Application for removal or variation of a condition following grant of planning permission.
Town and Country Planning Act 1990.
Planning (Listed Buildings and Conservation Areas) Act 1990

1.	<input type="text" value="CONDITION 3 - SPRAY SCREEN"/>	6.	<input type="text"/>
2.	<input type="text"/>	7.	<input type="text"/>
3.	<input type="text"/>	8.	<input type="text"/>
4.	<input type="text"/>	9.	<input type="text"/>
5.	<input type="text"/>	10.	<input type="text"/>

From: Dave Westhead <dave.westhead@stockport.gov.uk>
Sent: 13 October 2023 08:12
To: David Ormesher
Subject: FW: External: 366 Wellington Road North, Stockport SK4 3QP
Attachments: Scanned from a Xerox Multifunction Printer.pdf; Scanned from a Xerox Multifunction Printer.pdf

DRG TITLE
 PROPOSED SITE PLAN

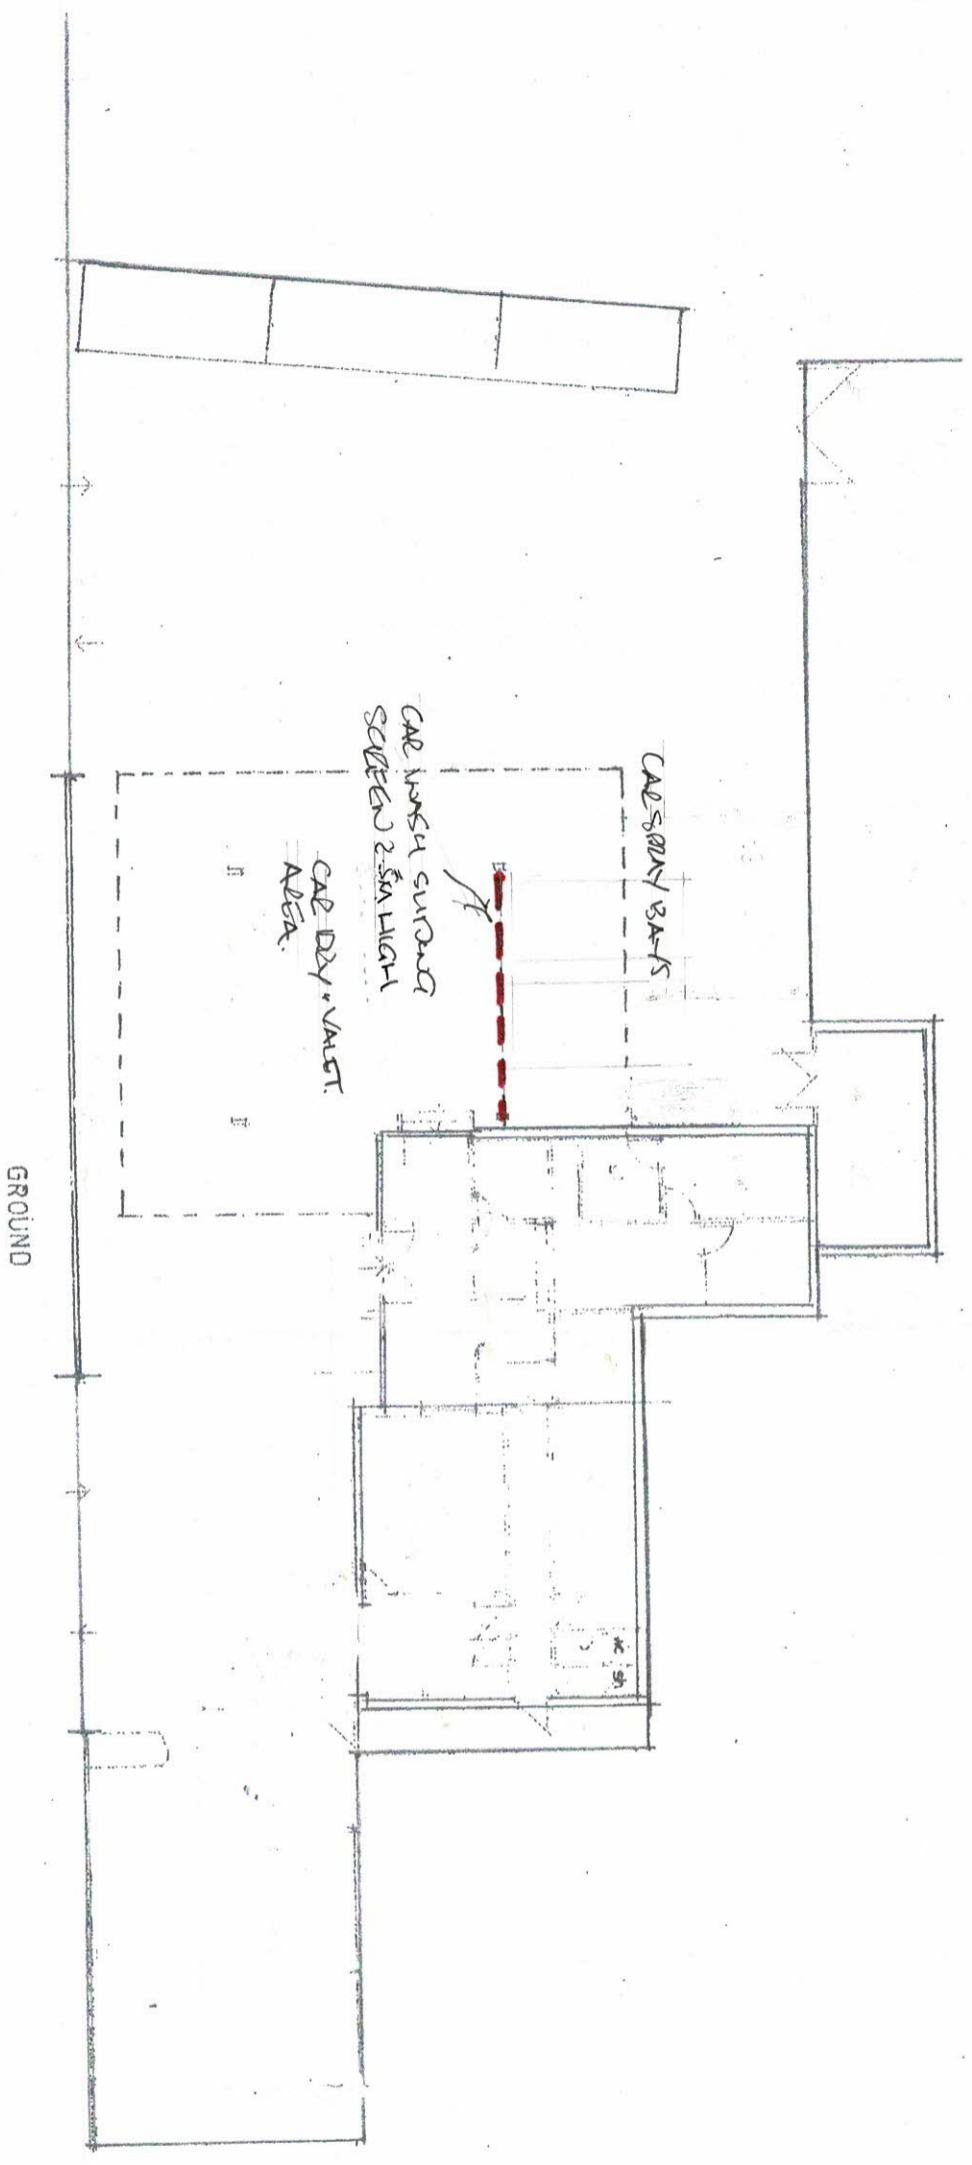
The screens that are required to be fitted are still not in place. However I did note that cars were being washed towards the rear of the site so that the correct drainage is being used, there are retractable plastic curtains being used to separate the washing area from the valeting area. There are on a wire and can be pulled back at the end of the days operation.

Your client currently has two in place but stated that he wants four of them.

If your client wants to operate the car wash with these retractable screens then an application for a variation of conditions is required to obtain approval for the current set up.
